Please find a more detailed objection to the proposed planning application. 2023/62/93237/W

I strongly object against the proposed development at 71 Coach Road, Cowcliffe, Huddersfield, HD2 2NW application number: (2023/93237). I have lived in my property No 8 Fixby park drive for over 30 years and during this time enjoyed the privacy and spectacular views from the garden and south facing rooms of my house which under the current application will be directly affected. The proposed development would have a significant harmful impact on the openness of this area and would be a negative addition to this prominent position and setting which has provided panoramic views, vistas across Huddersfield for the residents of this area since historical development. When considering this application, the local council must surely take into account the wider strategic perspective and oppose any development on this hillside on principle that it is much larger than those properties around it and it does not fit in with the adjoining 1960s style brick historical buildings and landscape.

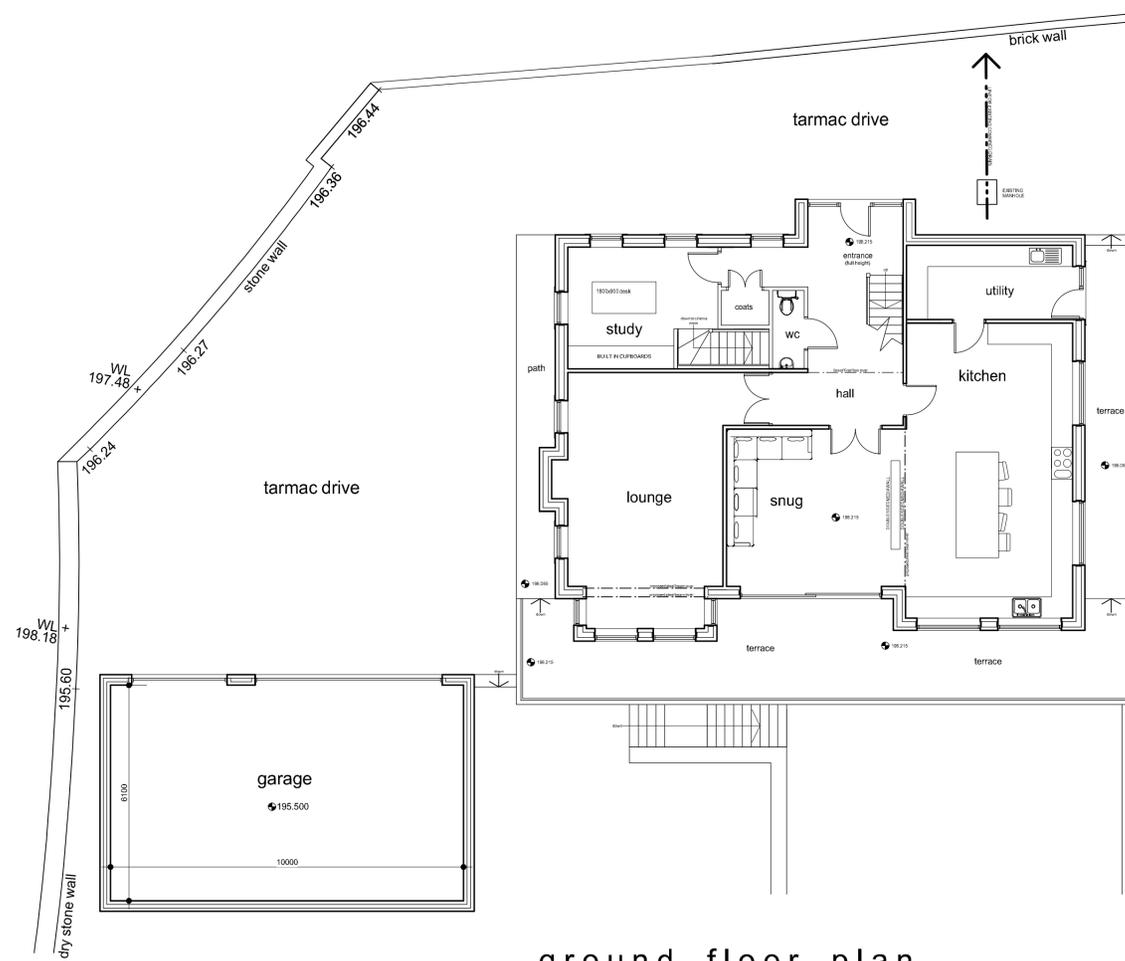
- The drawing indicates a high continuous stone wall to the northwestern boundary when this wall actually steps down to a far lower-level wall across the majority of this boundary with the ground level much higher on the opposite side giving a elevated view of the application site. The proposed triple garage as planned would create an infill between the main dwelling and historic woodland eliminating the openness of the area as well as preventing any view from the rear of the existing dwellings that they have always enjoyed. This also closes an access route for our local community of Badger, Fox and Pheasant.

create raised terrace to front of dwelling as shown - new external walling constructed with an outer leaf of natural local coursed stone.

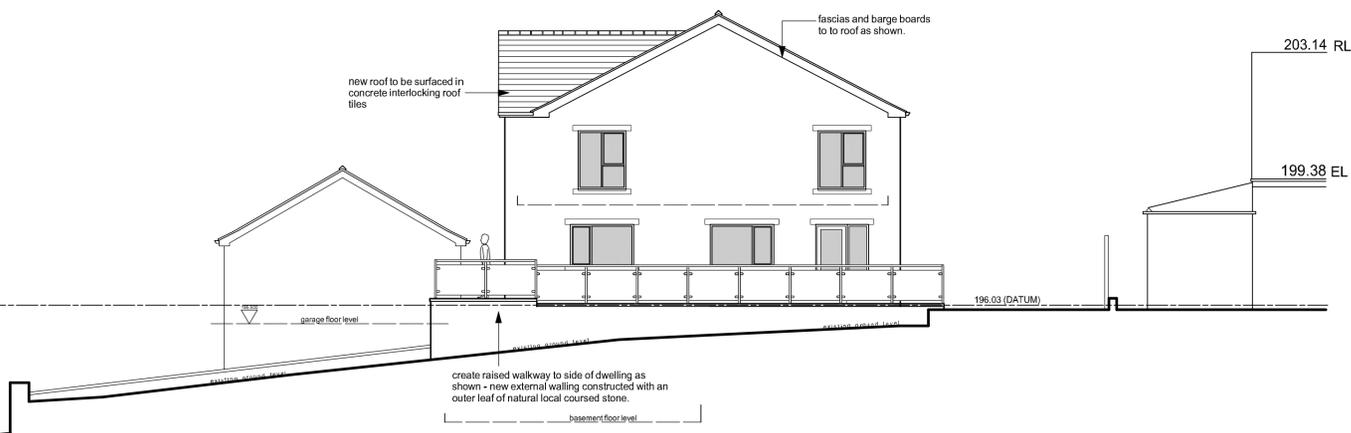
- The elevated terrace to three sides will allow overlooking into the adjoining amenity area of 8 Fixby park drive and over the existing road and public footpath.

north elevation

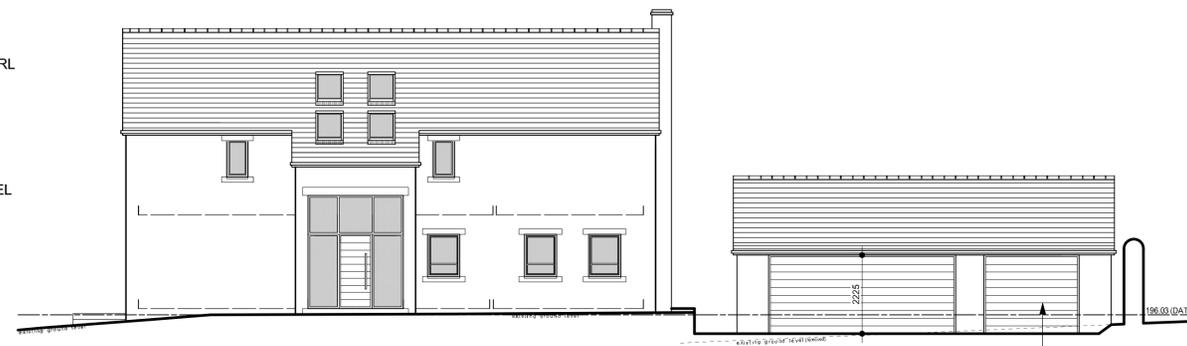
- The accumulative size and bulk will be overbearing to the adjoining properties.
- The proposed tall windows to the entrance and roof windows to t
- The proposed North elevation would allow a direct view into the adjoining bedroom and conservatory of 9 Fixby park drive which should be unacceptable for privacy reasons.
